GRADING & EROSION CONTROL PLANS FOR:
LATIGO TRAILS
FILING NO. 10
 EL PASO COUNTY
 FALCON, COLORADO

**CONESTOGA TR.
 GRADING &
 ERSN CNTL PLAN**

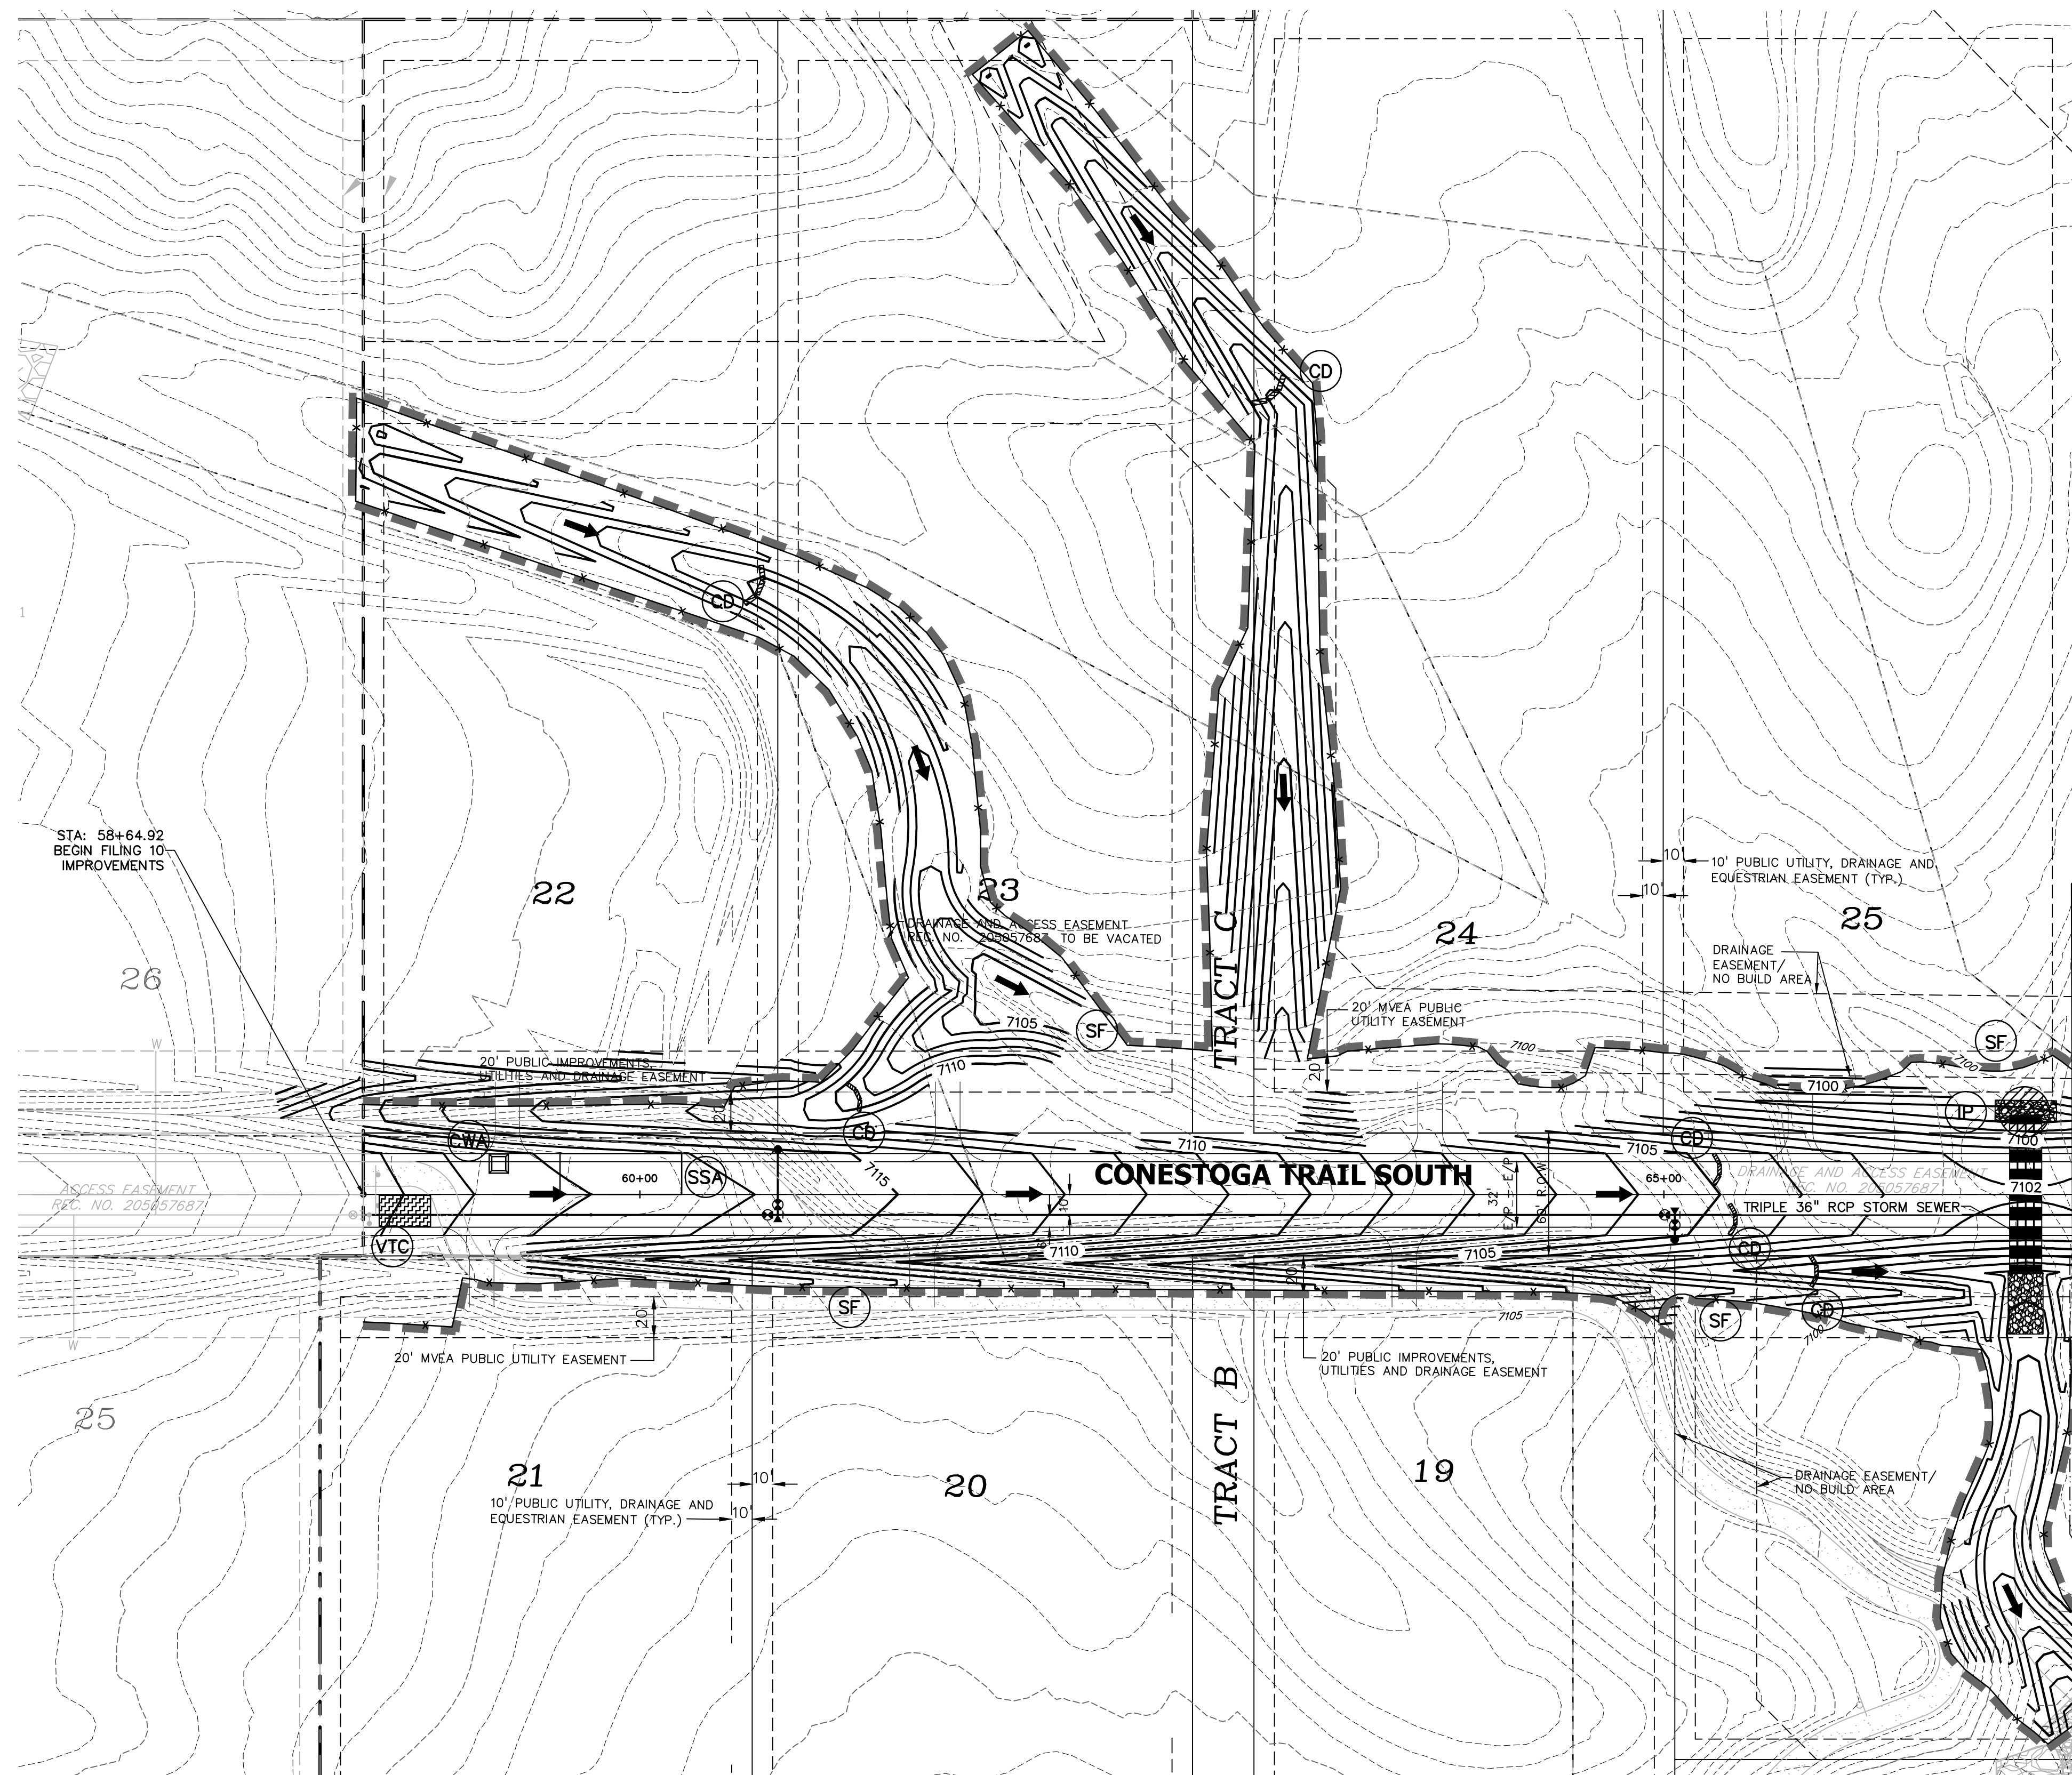
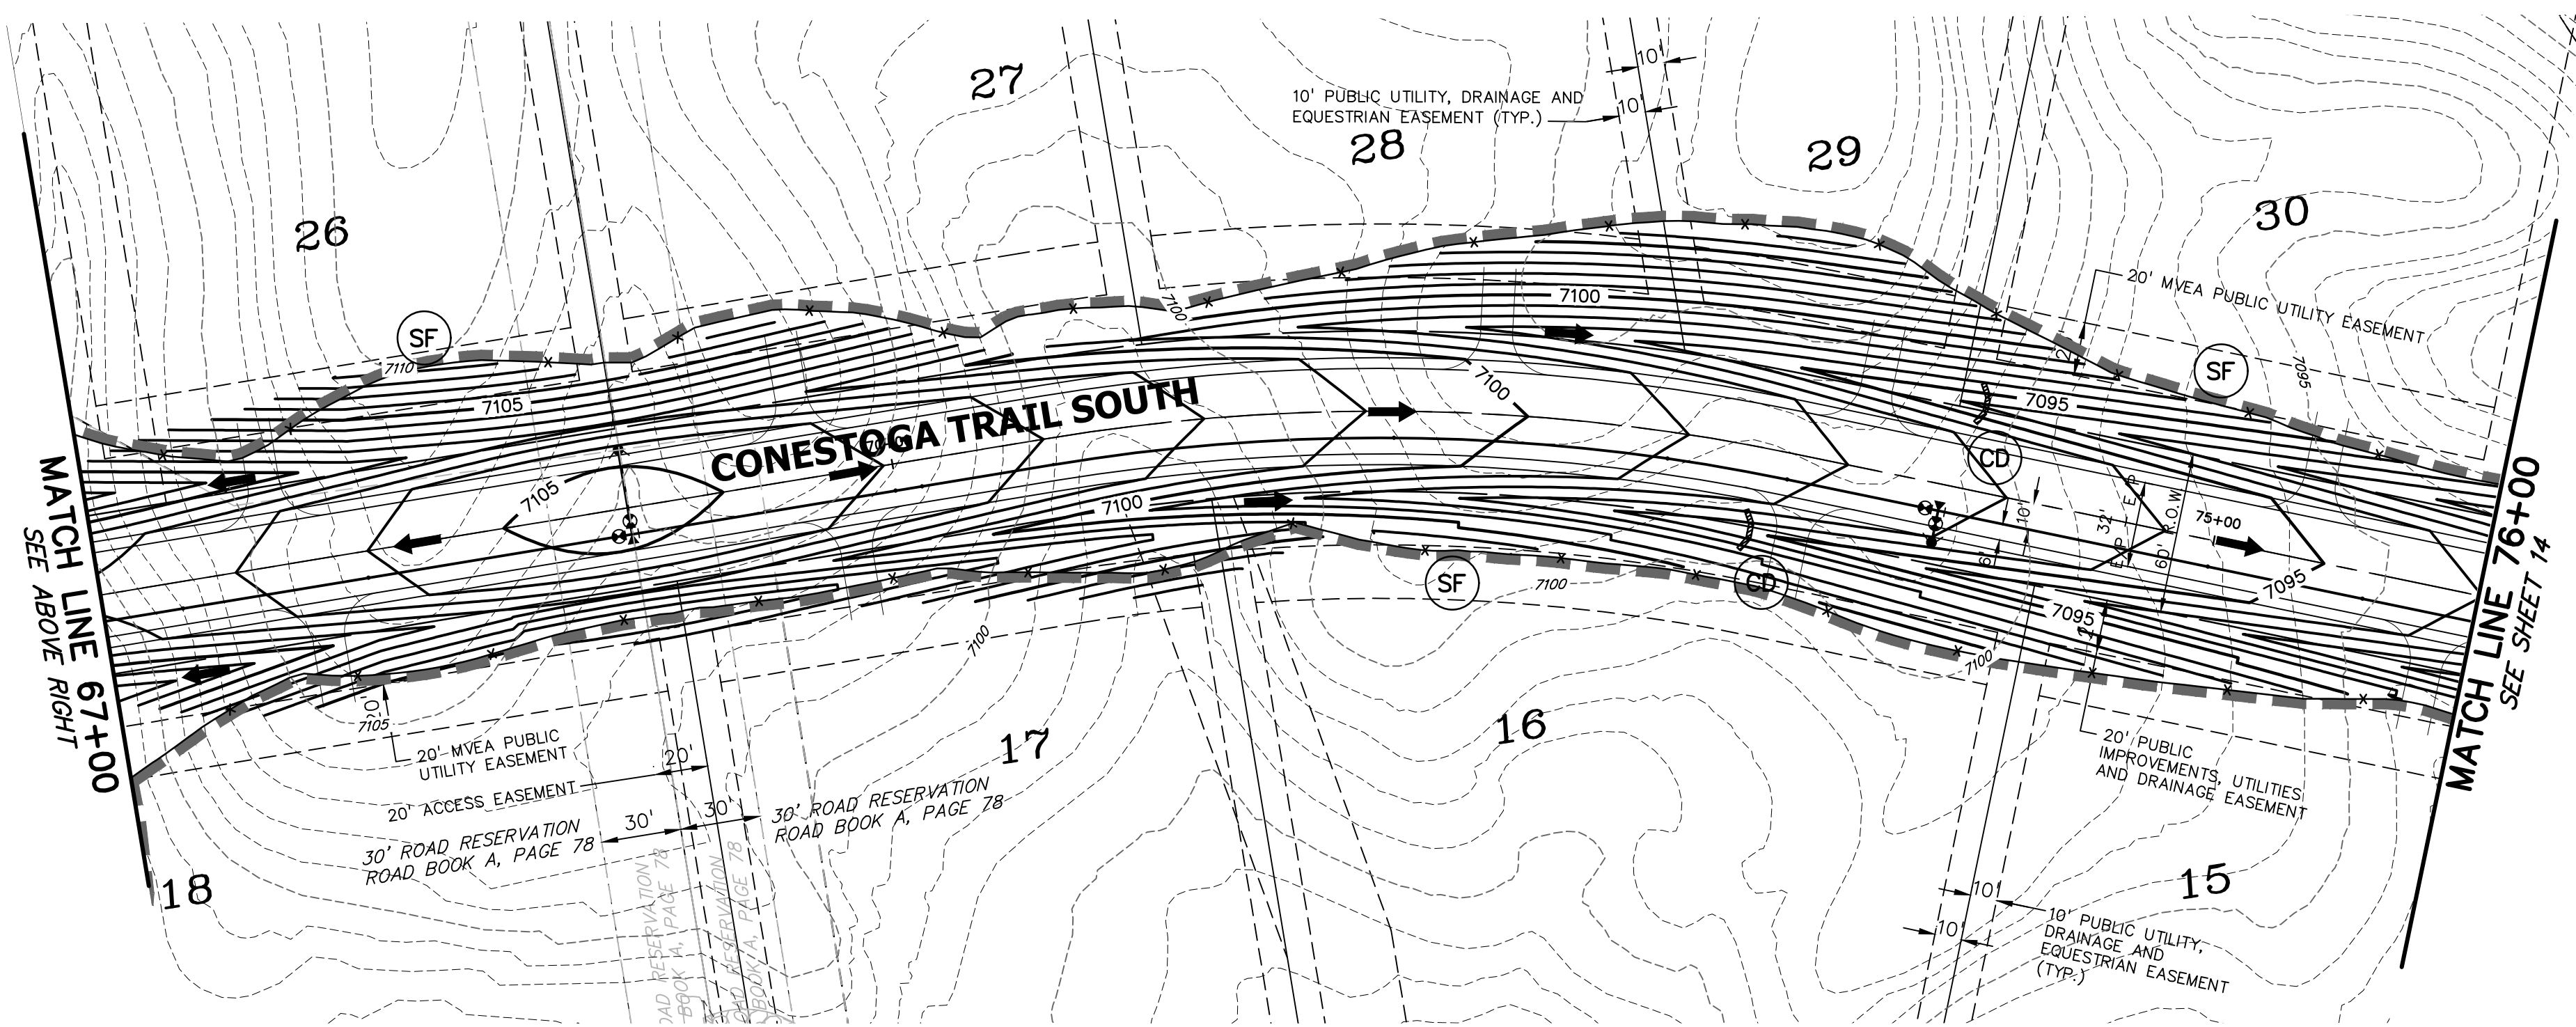
Show seeding/mulching in legend and on the plans.

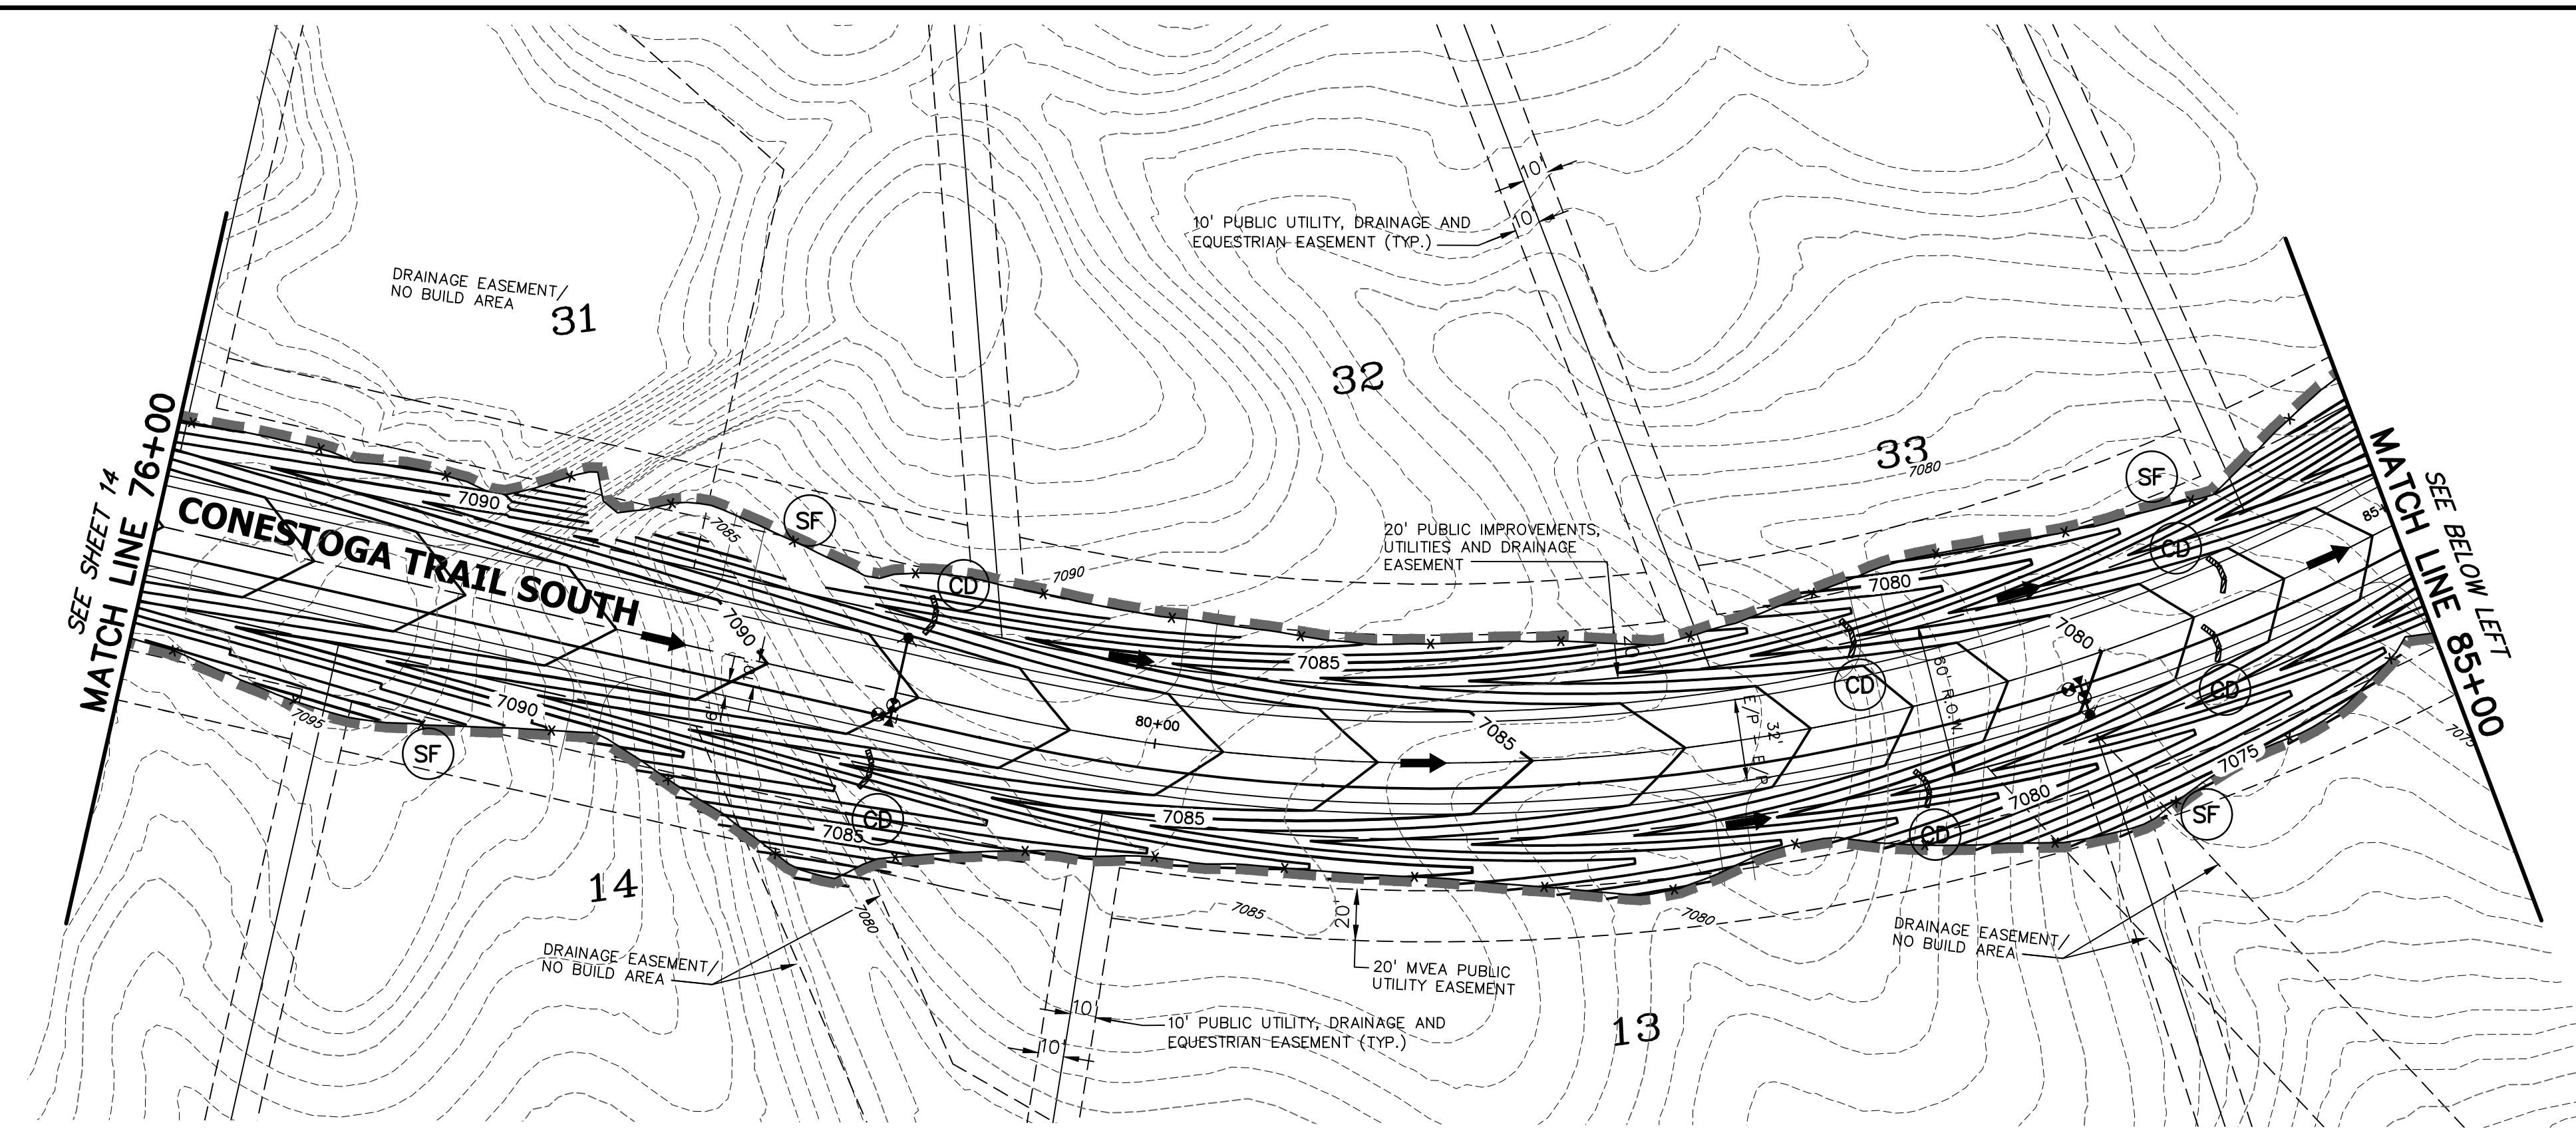
This pond will be a TSB in the initial/interim condition. Label. Provide details of temporary sediment basin including riser pipe diameter and perforation sizing, number of rows of holes, required volume, location of outlet pipe and spillway, and tributary area to the sediment basin. And provide contours for sediment basin.
